Item No. **Report of the Head of Planning, Transportation and Regeneration**

Address 5 VERBENA CLOSE WEST DRAYTON

Development: Single storey rear extension

LBH Ref Nos: **75489/APP/2020/965**

SITE PLAN - SIGHT LINES

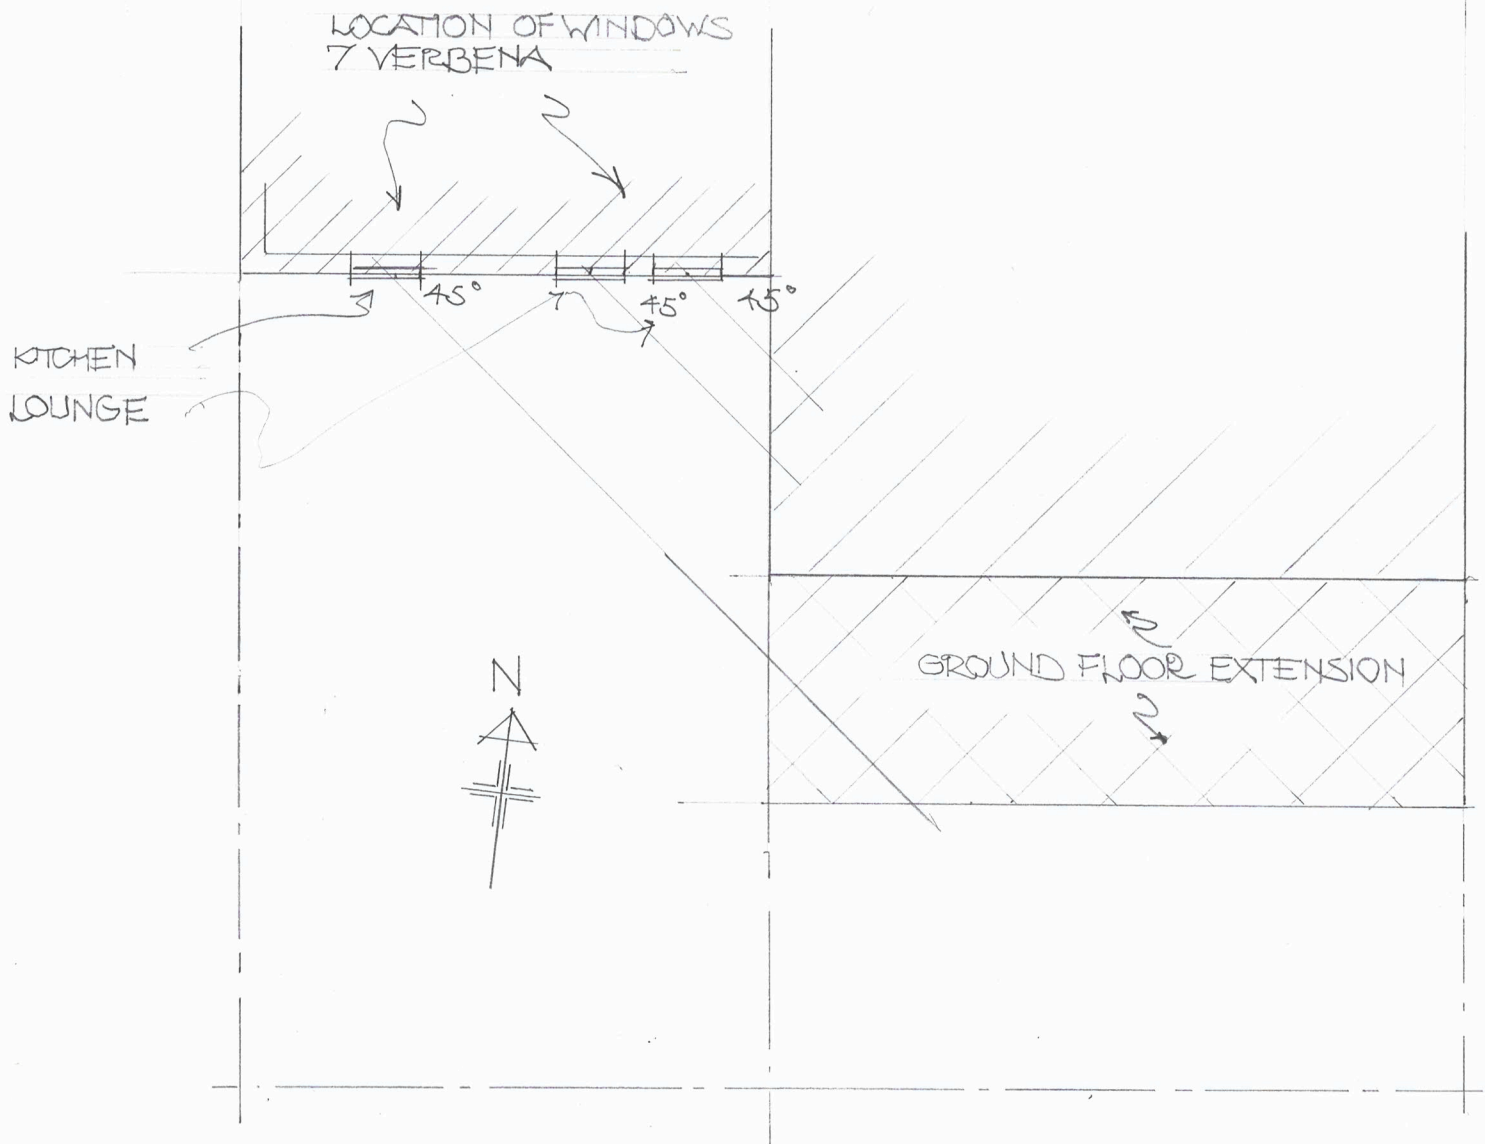
The adjoining attached property comprises two flats, Nos. 7 and 8. This property is sited so that the application property is set some considerable distance beyond the rear elevation of Nos. 7/8. The proposed ground floor rear extension, whilst being 3m in depth, when considering the siting of 7/8, would result in an extension of some 7m to the rear of the ground floor flat. No.7, which would have an unacceptable impact on the amenities of this property. Thus, the proposed single storey rear extension, by virtue of its size, scale, bulk, depth and proximity, would be detrimental to the amenities of the adjoining occupier at 7 Verbena Close, by reason of overdominance, overshadowing, visual intrusion, loss of light and loss of outlook. Therefore the proposal would be contrary to Policies DMHB 11 and DMHD 1 of the Hillingdon Local Plan: Part Two - Development Management Policies.
